NORTH FALLS

Offshore Wind Farm

Applicant's Response to Natural England's Deadline 6 submissions

Document Reference: 9.101
Volume: 9
Date: July 2025
Revision: 0

Figure 4-1 Contour plot showing the interaction between two noise sources when occurring simultaneously (TTS in fish, 186 dB SEL_{cum}, fleeing animal)

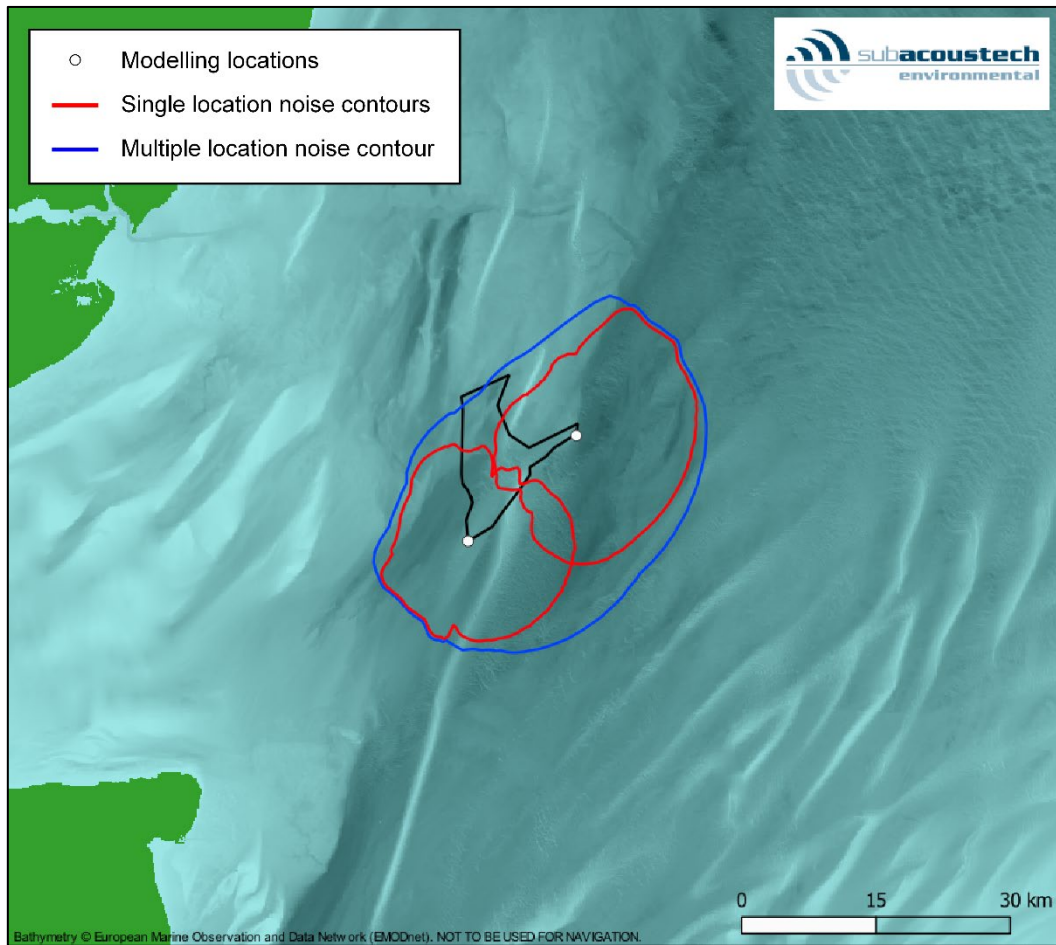
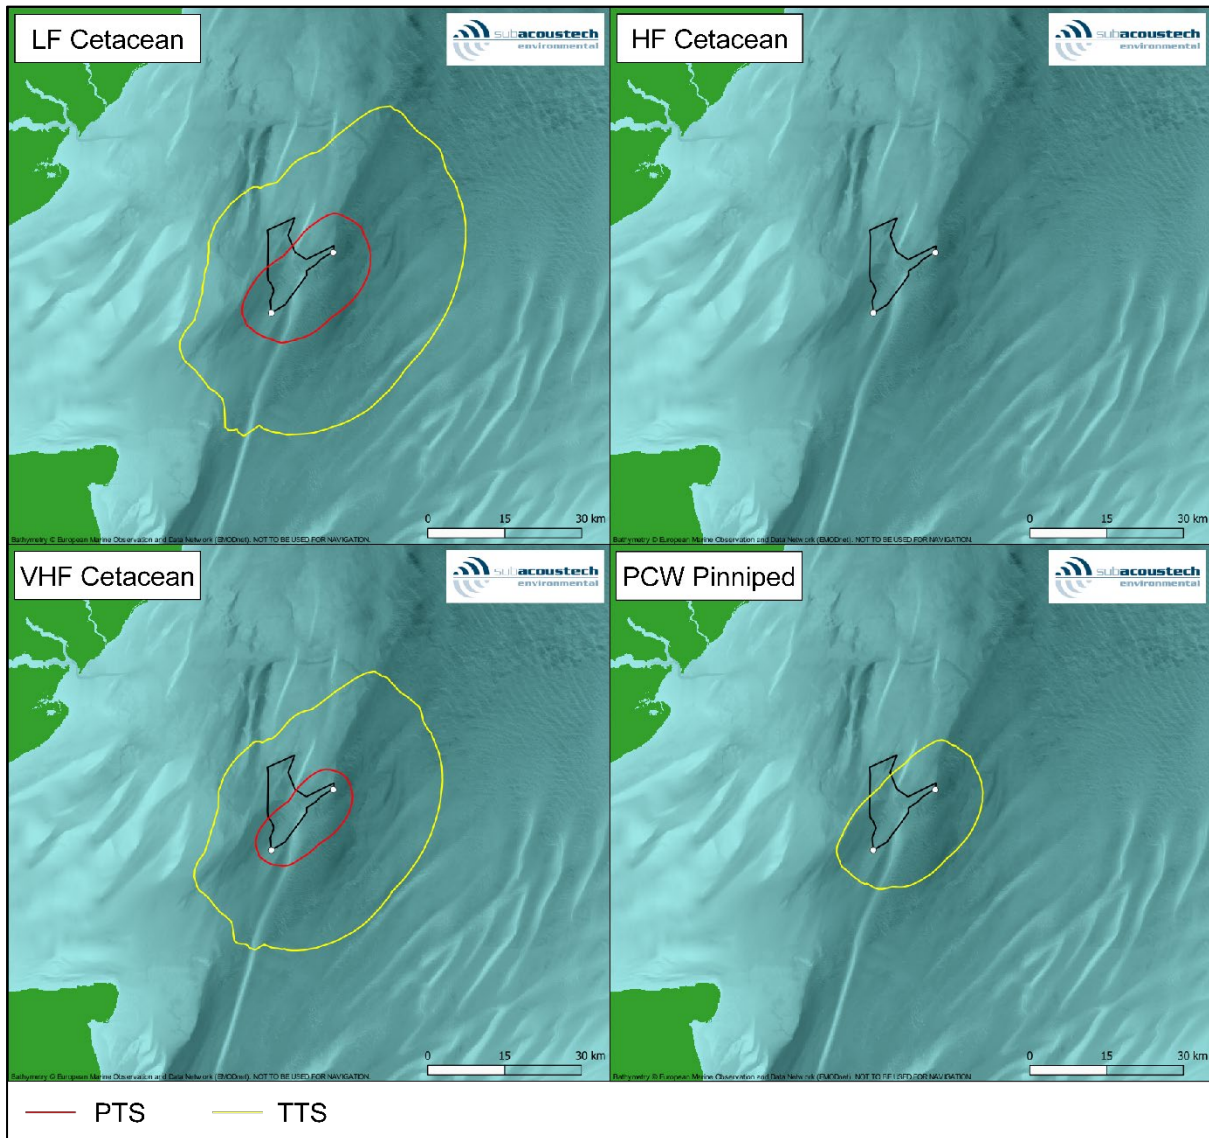
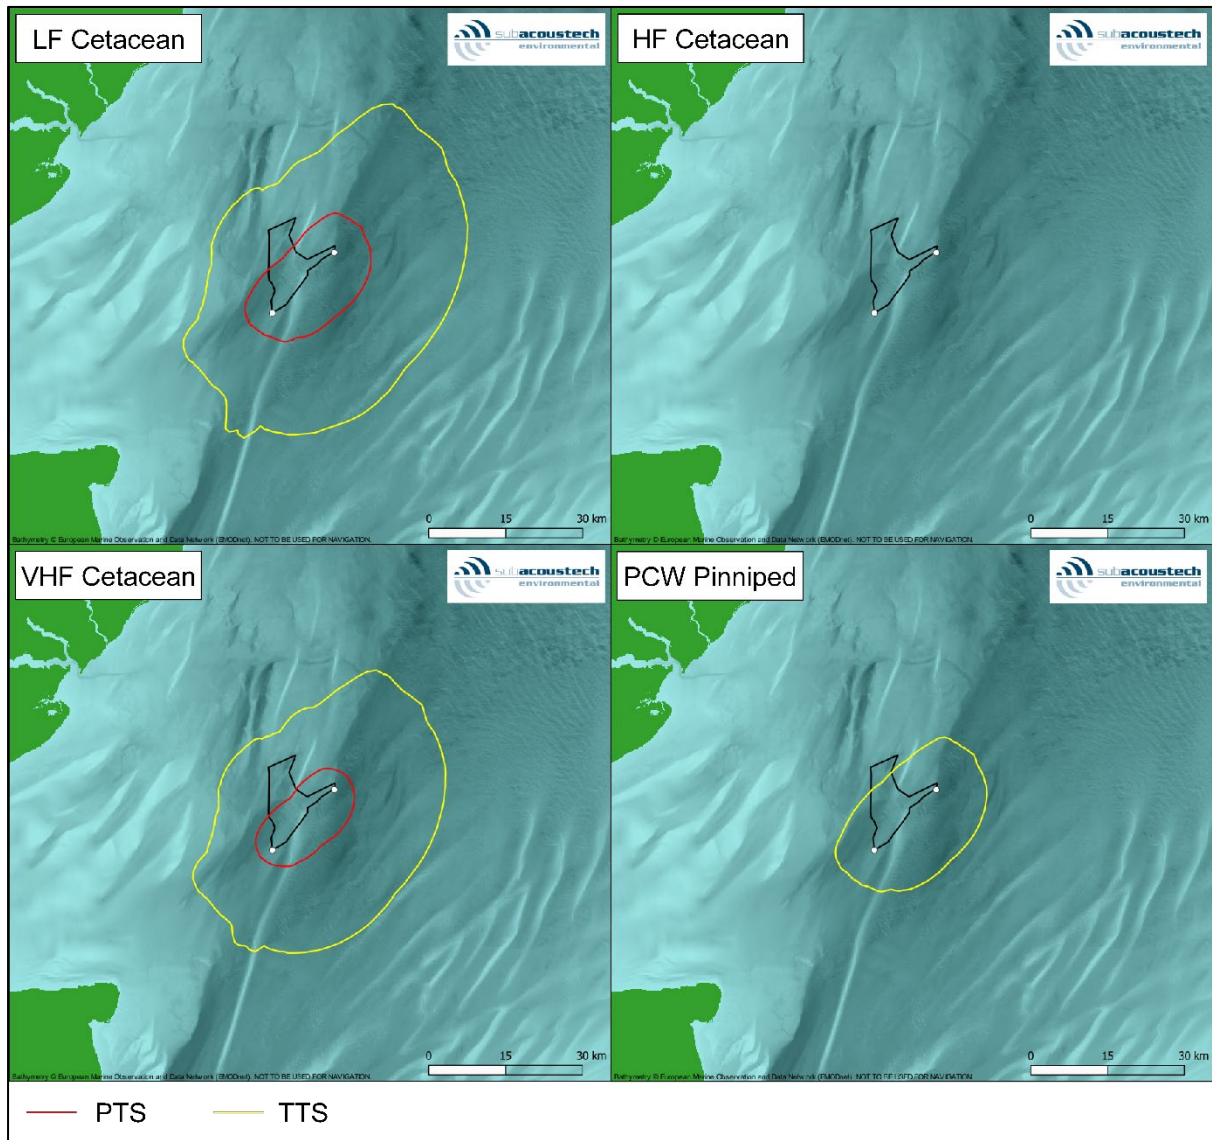
REP6-089_e4		5	E6, E34	We note that the multiple piling scenario includes simultaneous piling at East and South locations as the worst-case scenario (WCS). Natural England has concerns that the WCS no longer includes the North and South locations, as described in pre-application documentation, resulting in a reduction in the estimated number of impacted animals. Natural England highlights that the multiple piling scenario should include the combination of locations that produces the greatest estimates of impacted animals in order to constitute an accurate WCS. Natural England advises that the Applicant should re-calculate the simultaneous piling	No change.		No change		This has been responded to in REP6-059, the Applicant emphasizes that the assessments have already been based on the two locations that produce the WCS.
